SSD 5752, Sydney International Convention, Exhibition and Entertainment Precinct – Redevelopment of convention centre, exhibition centre, entertainment facilities and associated public domain works (SSD) is referred to as **PPP**

Sydney International Convention, Exhibition and Entertainment Centre Precinct – Mixed use Development in the Southern Haymarket Precinct (Concept Proposal) (SSD) is referred to as **PDA**

Figure 8-33 RMS Crash Data for a Five year period (July 2007 – June 2012)

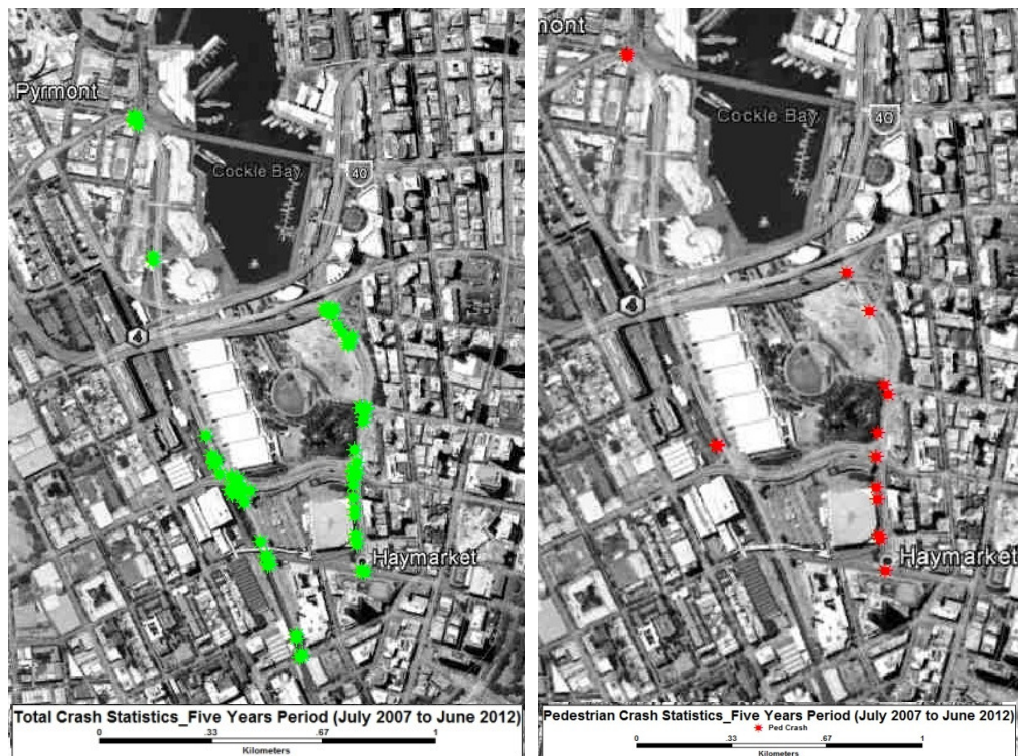
Vehicles turning right from Darling Drive into Ultimo Road, with the intention of turning left onto Harris Street have no option but to turn into the RH lane (as if to turn right onto Harris Street) and then push into the left hand lane across the cycle path. This is the only way to get 4-6 cars, per traffic light cycle, from Darling Drive onto Ultimo Road. When Darling Drive is fully utilised under the new development, there will be LoS E (unacceptable) condition at the junction with Ultimo Road.

At the Western end, in busy periods, cars normally have to wait about 8 sets of lights to turn right (west) at the fishmarkets. The study notes this is a Los E (unacceptable) condition.

**DEVELOPMENT APPLICATION
 VIEW IMPACT ANALYSIS
 PEAK TOWER - HIGH LEVEL - NORTH
 RL 115.375**

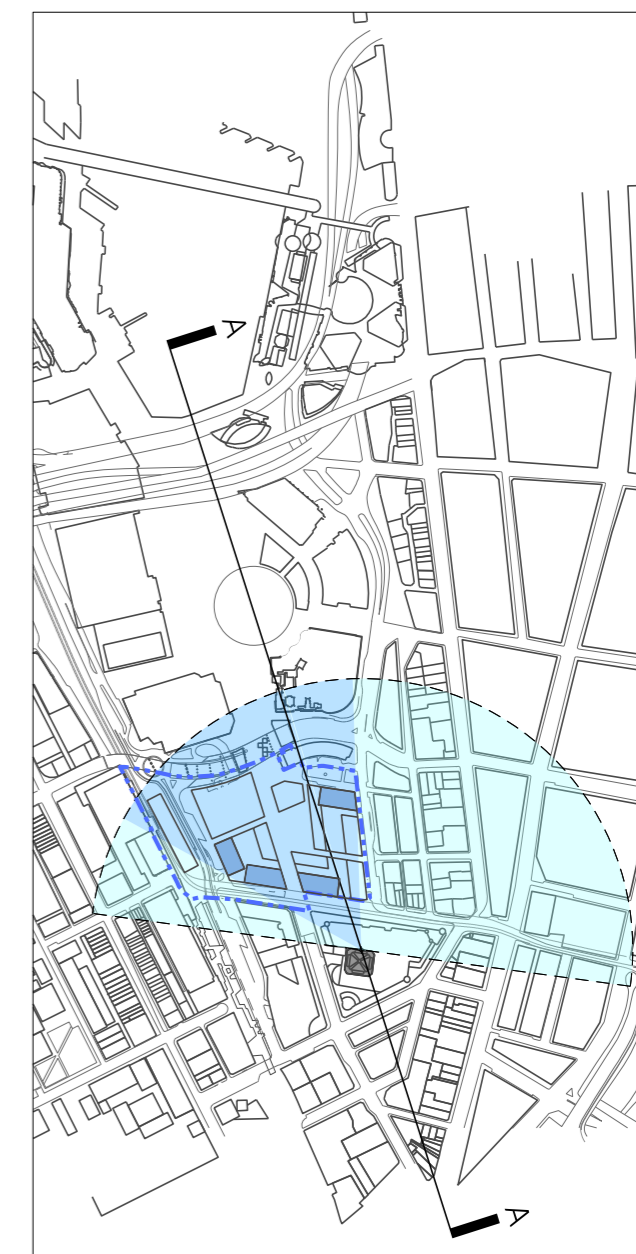
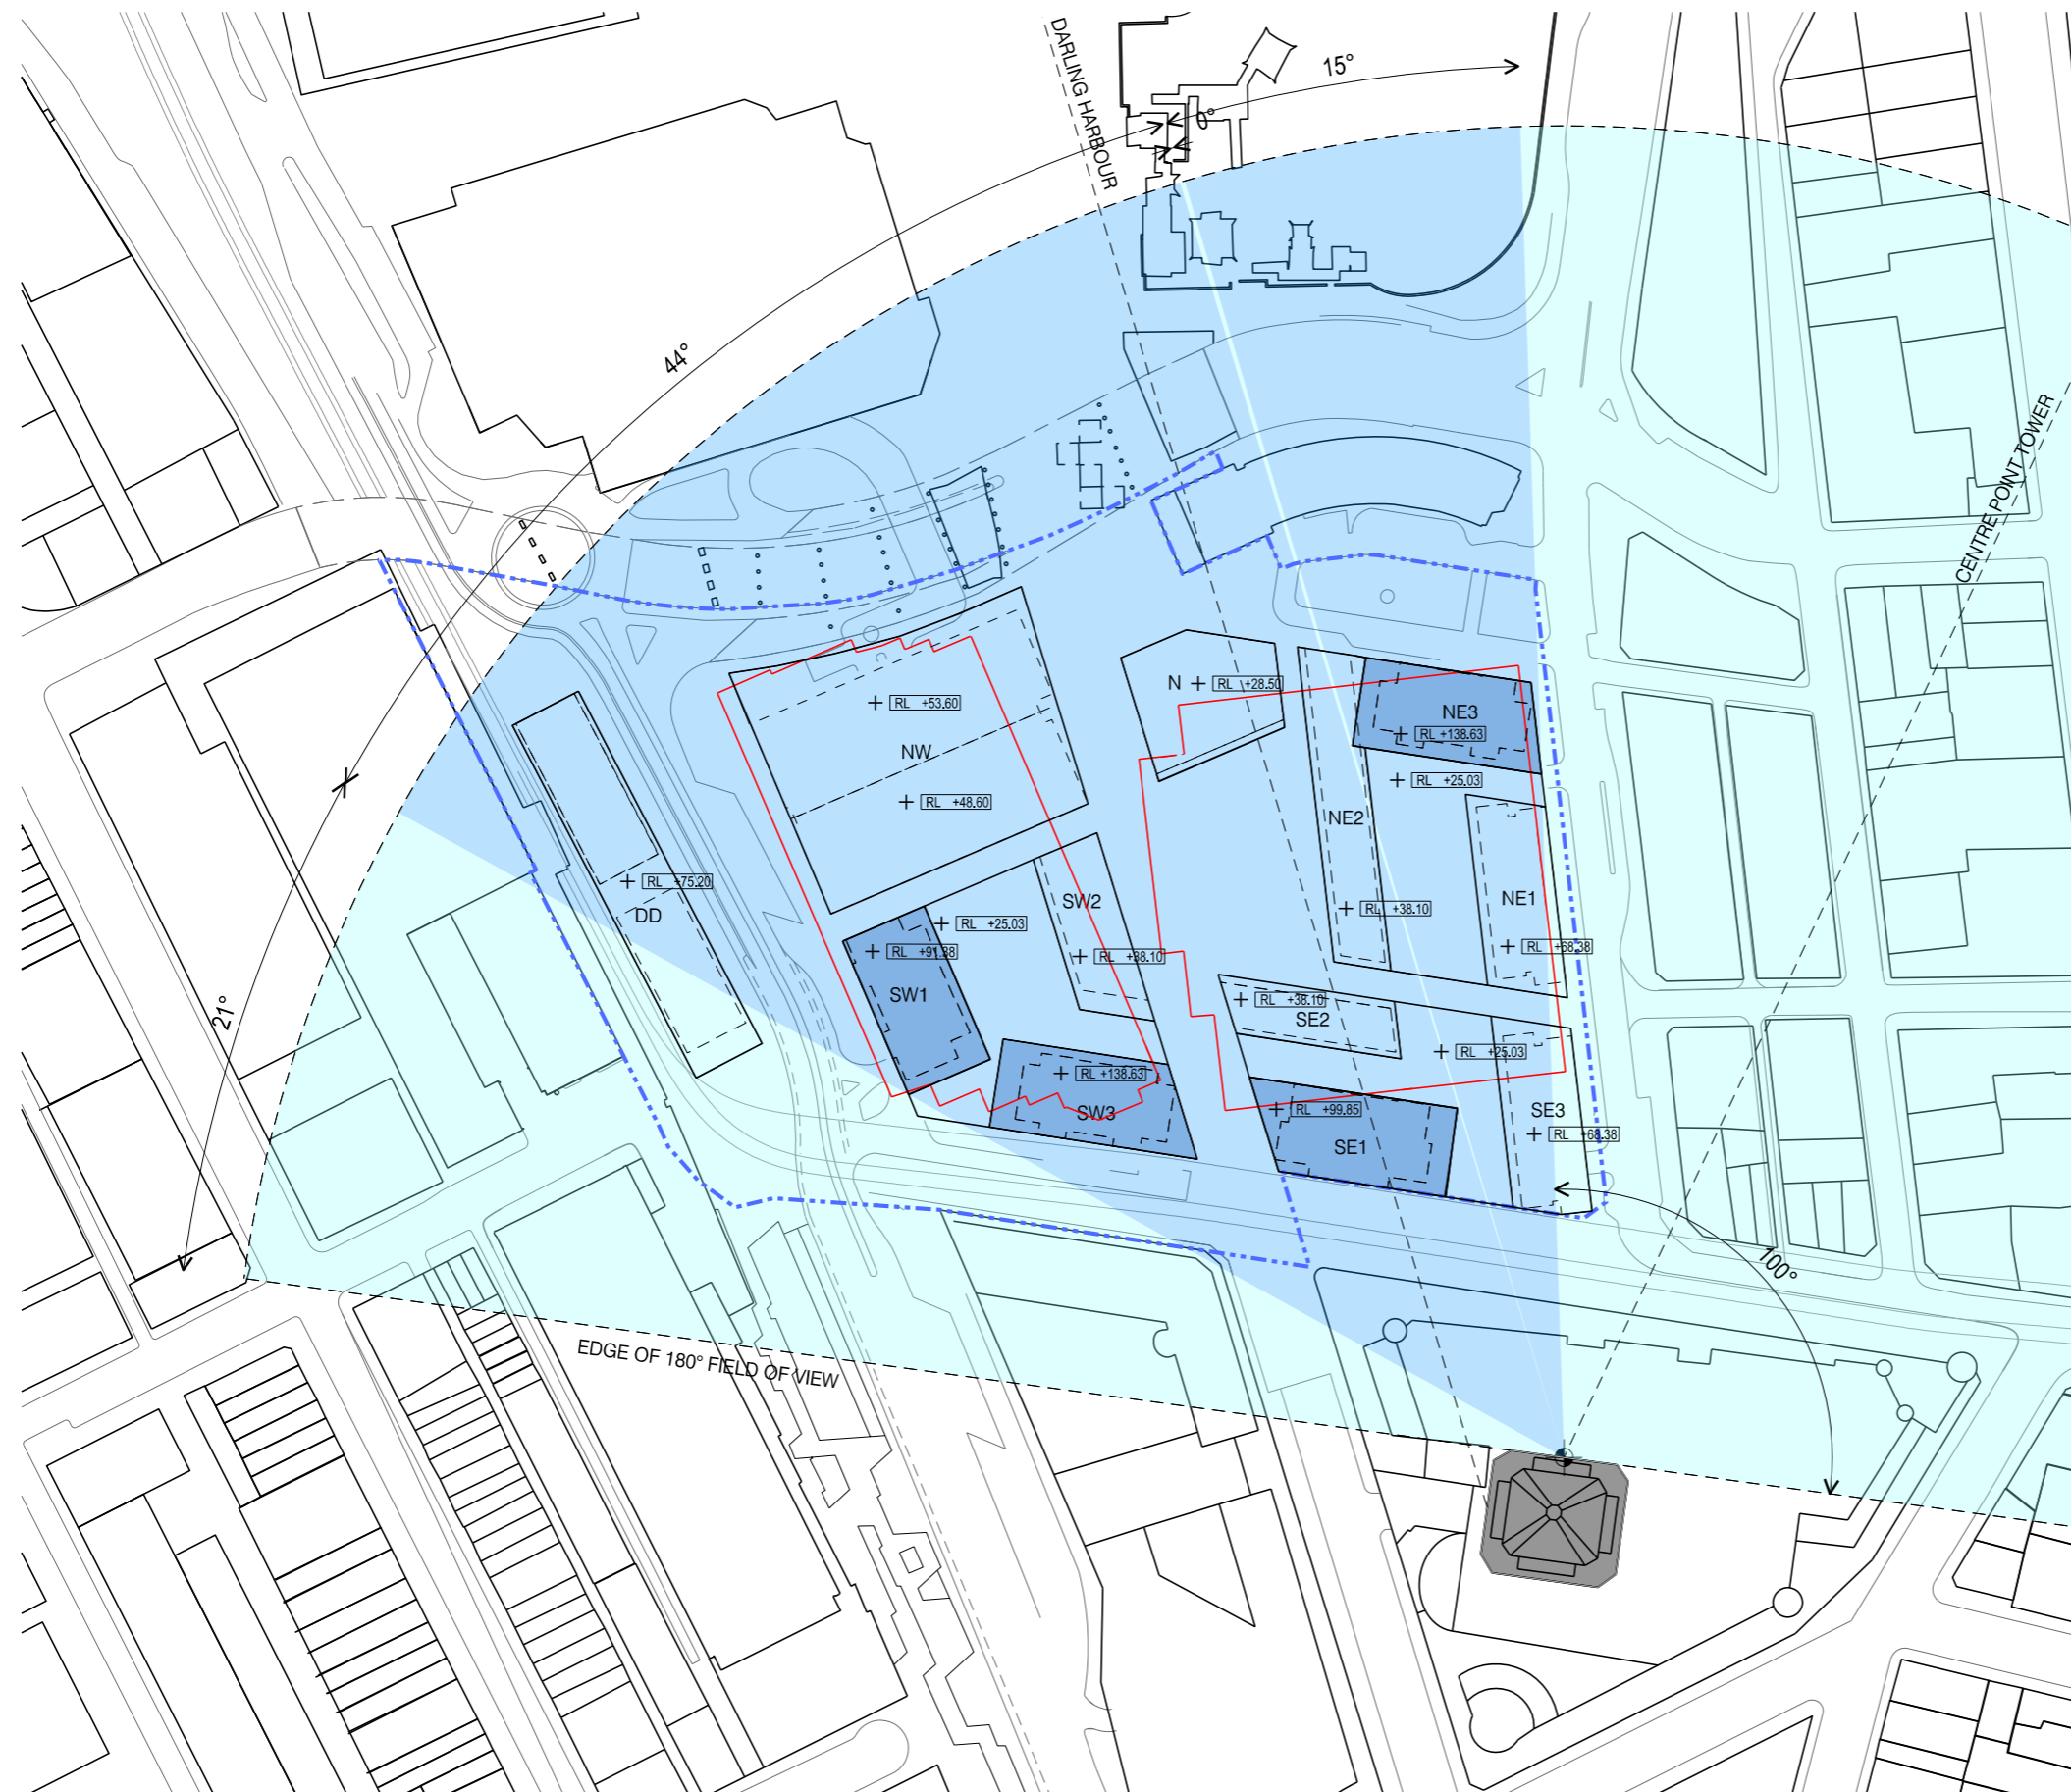
Even those on the topmost floors will be affected. Today their view is ...

Which will become ...

Only those on the top few floors of The Peak will retain more than 20% of their northward views. View sharing just is not on the Lend Lease agenda. Normally public views take precedence over private views. In this case new private views will take precedence over existing private views.

**DEVELOPMENT APPLICATION
 VIEW IMPACT ANALYSIS
 PEAK TOWER - MID LEVEL - NORTH
 RL 81.125**

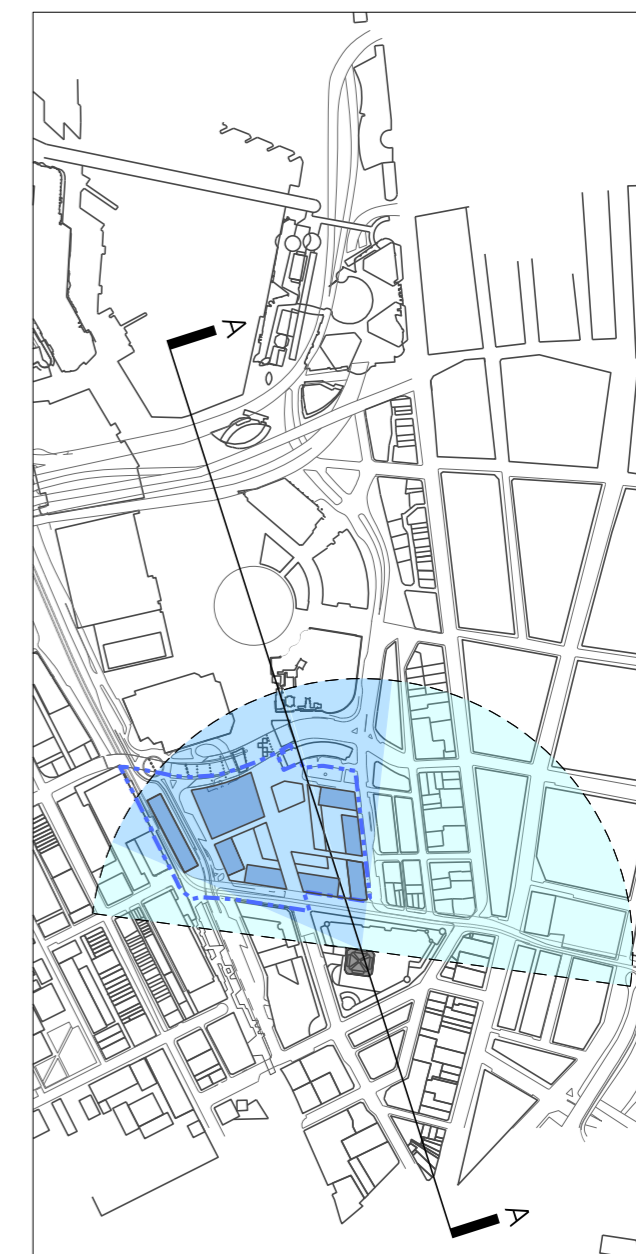
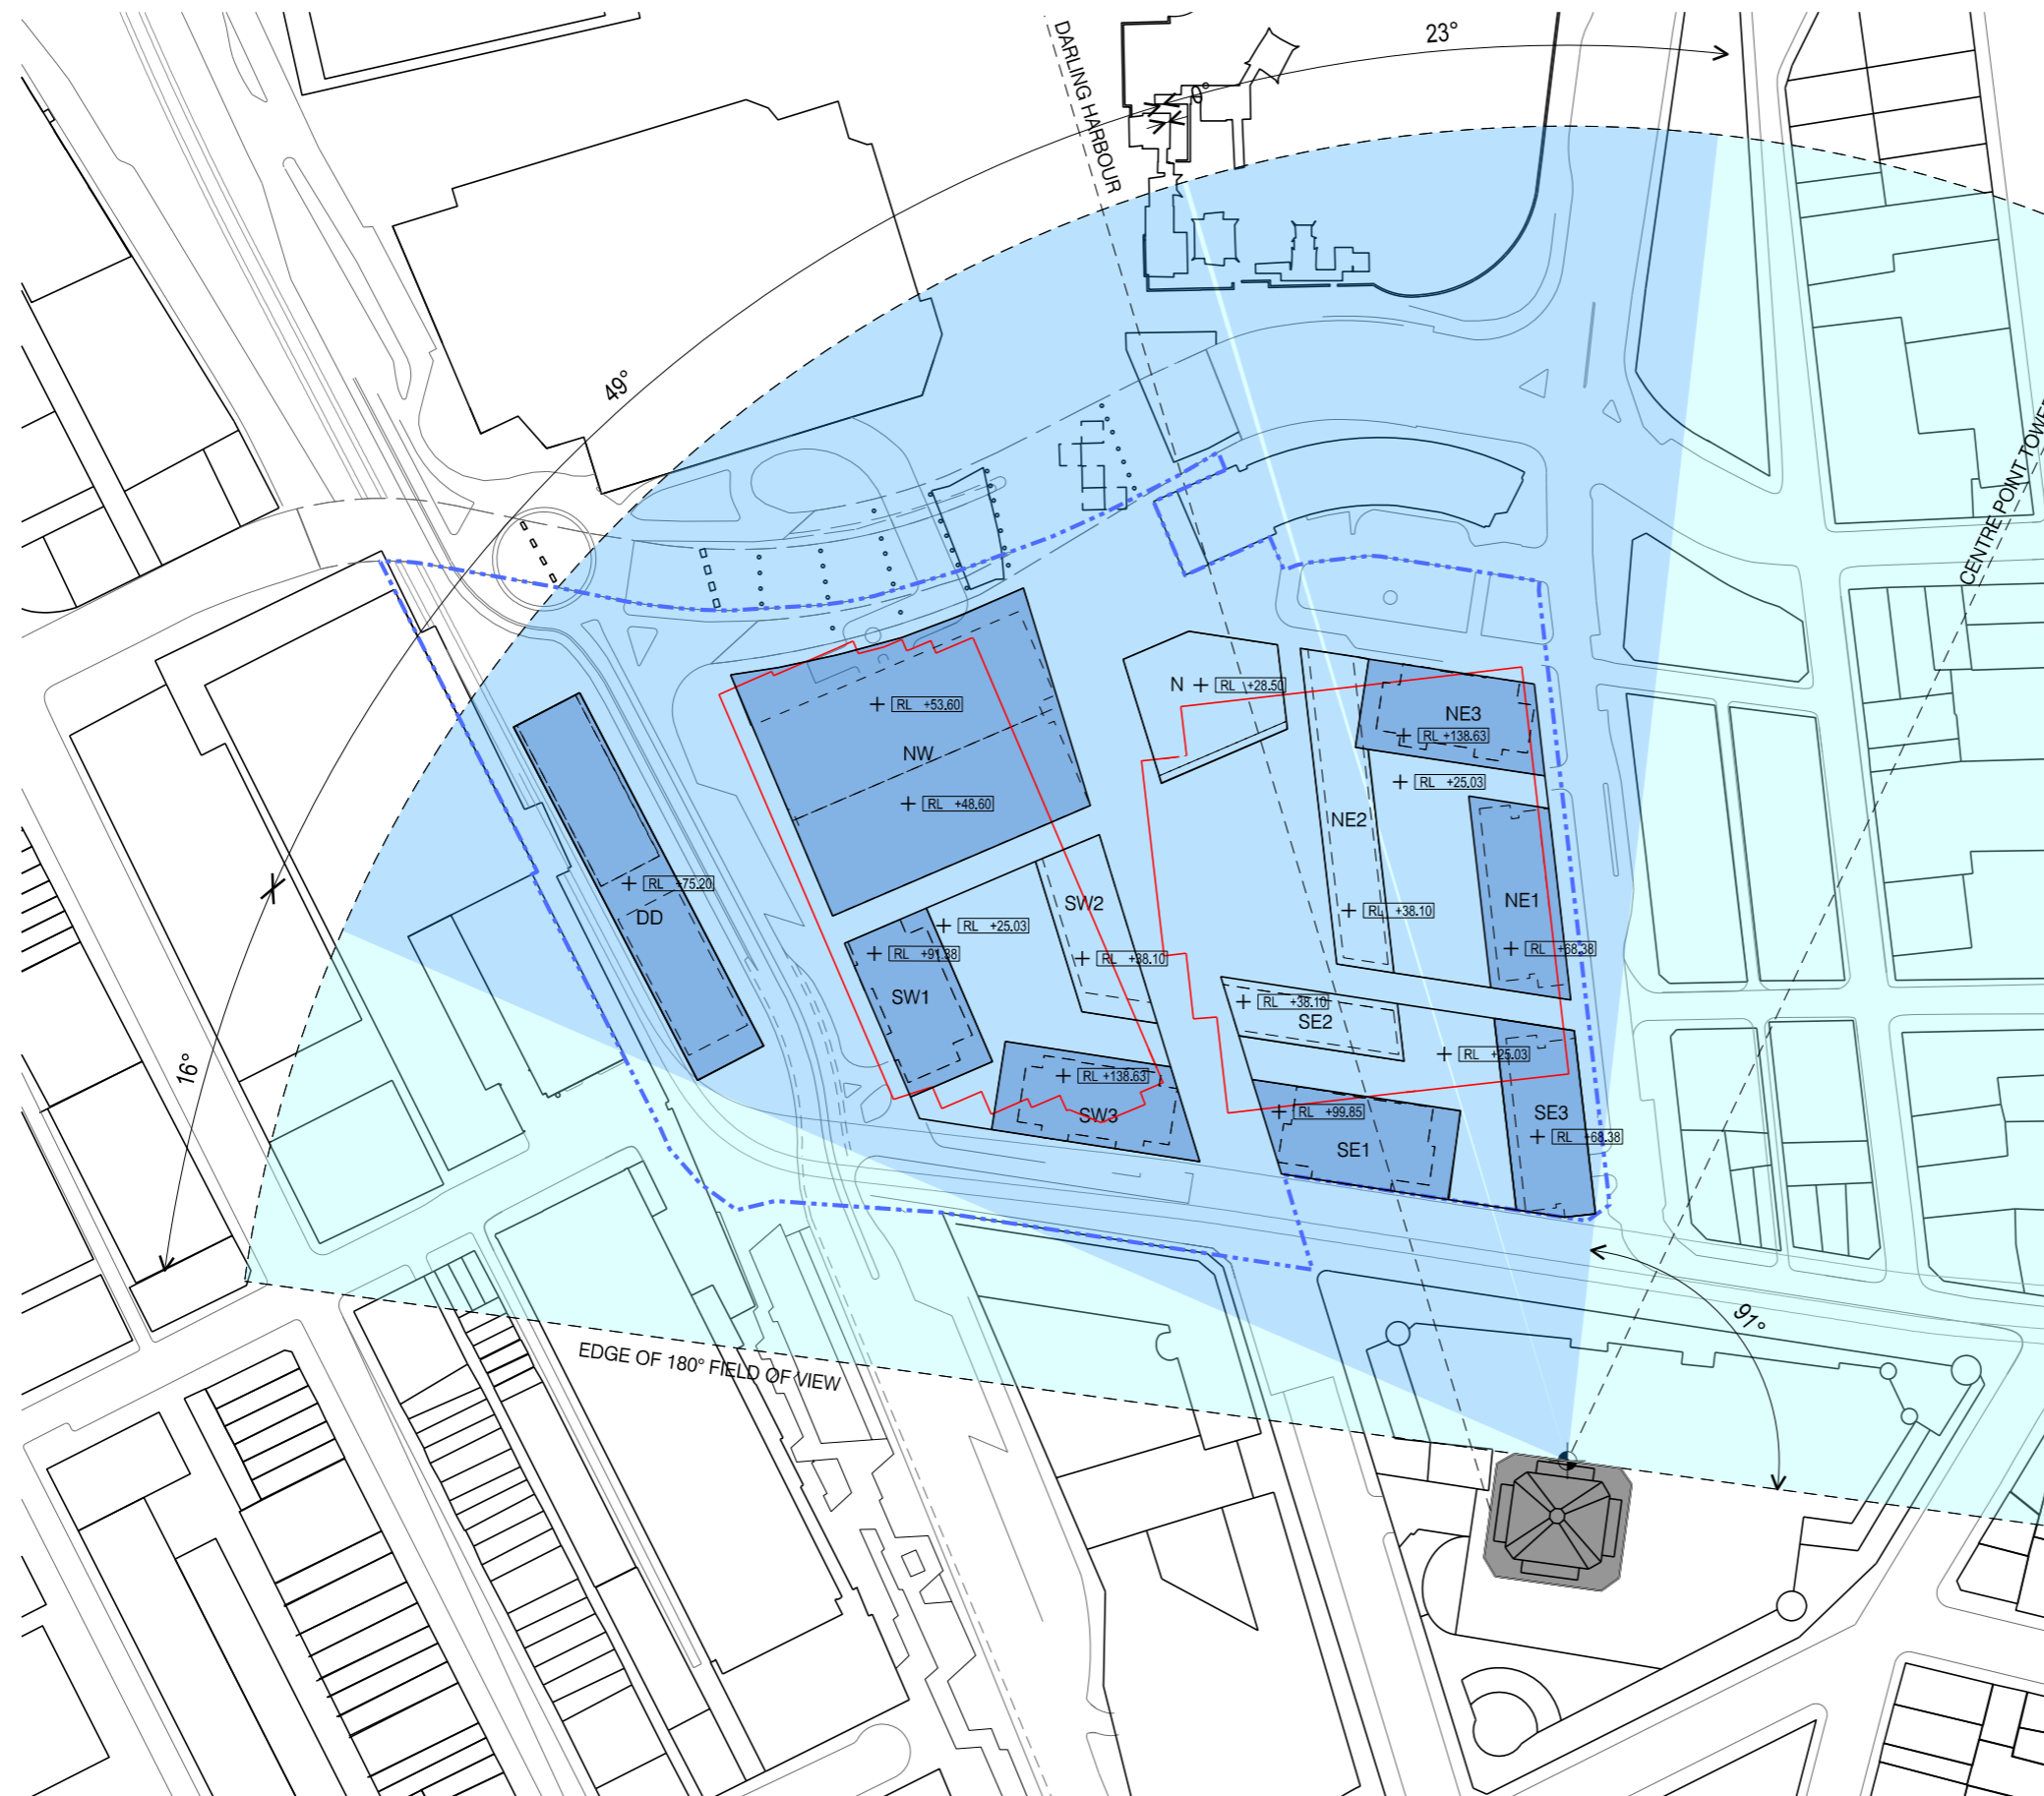
Those living on the middle floors today see this view ...

They have this to look forward to ...
